Response to Planning Application

From: Arun District Council Greenspace

Application ref: P/49/21/RES

Location: Land North of Sefter Road & 80 Rose Green Road Pagham

Drawing No CSA/2038/126

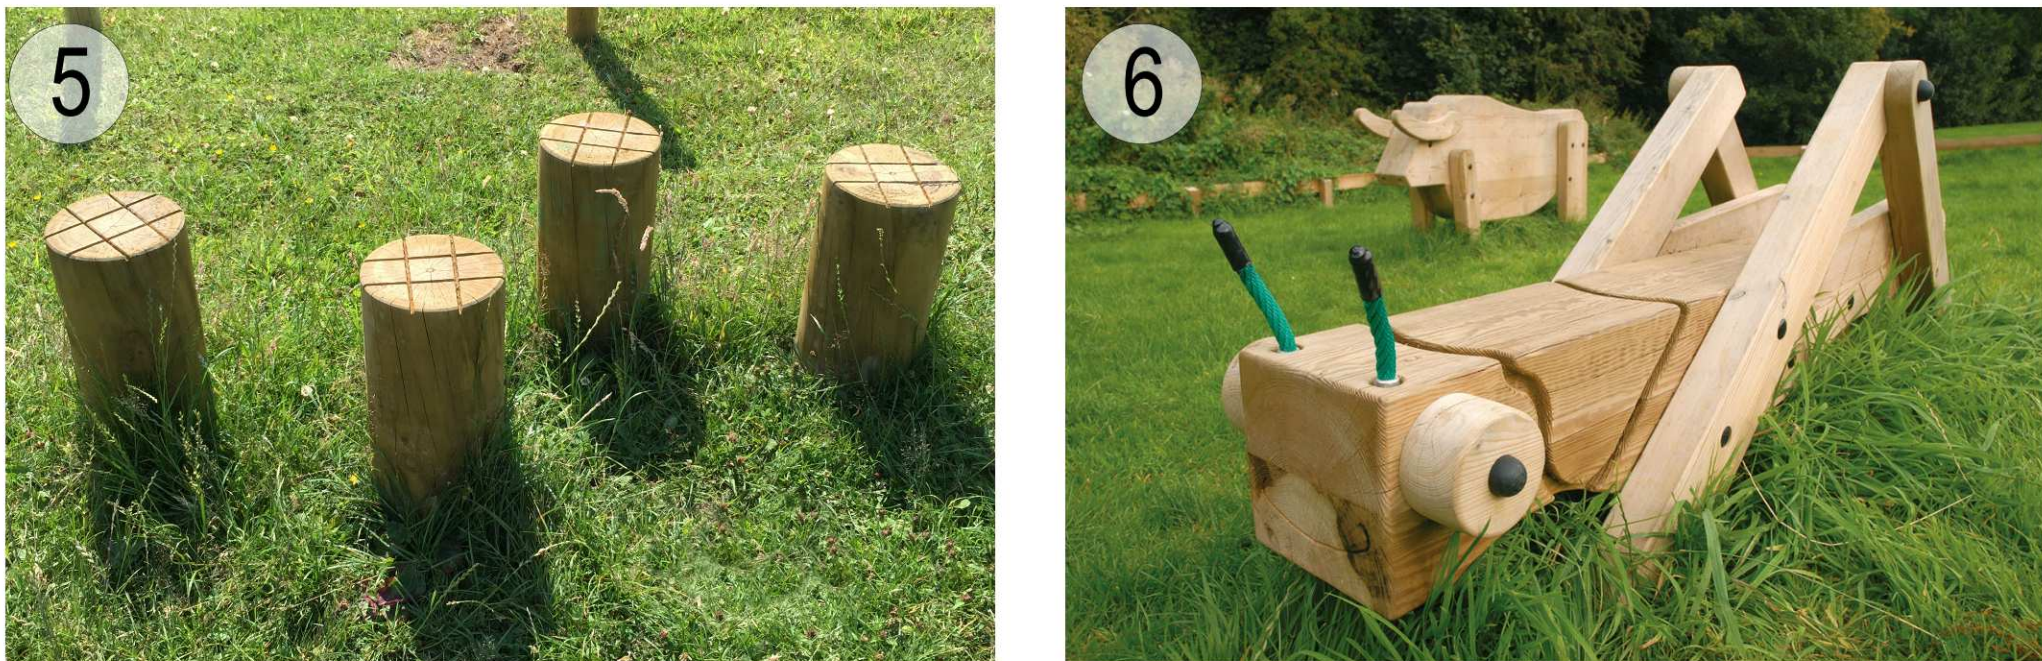
Previous consultation and 106 agreement had concluded in a requirement for an enhanced ELEAP catering for a minimum 8 play experiences and for there to be several LAPs located within the site. These are now shown and detailed within POS Dwgs CSA/2038/124 Rev B – LAP 1, CSA/2038/126 Rev B – LAPs 2&3, CSA/2038/128 Rev B – LAP 4. These LAPs appear to be well thought out, contain a good range of informal play and will be a valuable asset within the development. Detail has also been provided re the provision of the ELEAP within Dwg CSA/2038/139 ELEAP Playground Proposals. This detail has proposed a good play area offer containing equipment choice, surfacing, fencing and connectivity to the pathway network for the formal play.

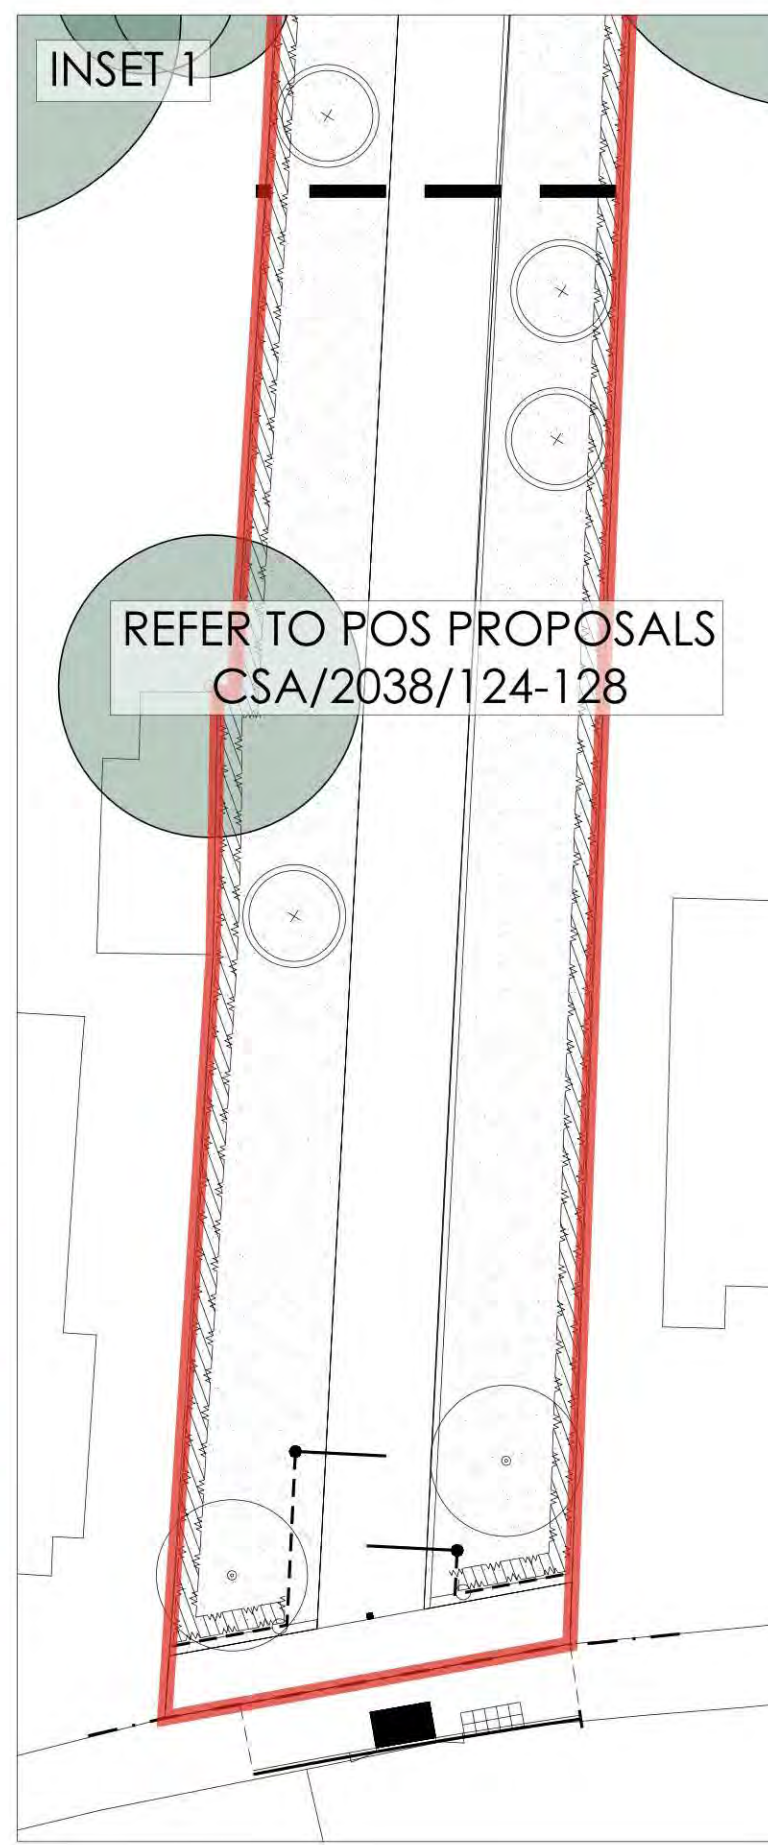
The submission of detailed information contained in the POS Landscape Proposals Sheets 1-5 of 5 Dwg nos CSA/2038/129/-133 inc Rev B contain detailed POS, open areas, boundary and periphery buffer planting, marginal and pond treatments with trees and shrubs, wetland and grassed areas. These details would appear to be adequate for these areas, with sufficient detail given and proposing a scheme which would be suitable for location adding to biodiversity habitat as the scheme develops in these areas. A large proportion of the usable POS areas appear to the periphery of the site where buffer zones incorporate the existing tree presence. This is good to see and to be encouraged in an approach to retain and protect existing green features and the biodiversity habitat already formed in this area.

Landscape Proposals sheets 1-5 of 5 Dwg nos CSA/2038/129/Rev B have now provided the on plot landscape detail which was lacking on previous applications and provides the information in sufficient detail in plan form detailing species choice, actual quantities, planting densities and size at time of planting.
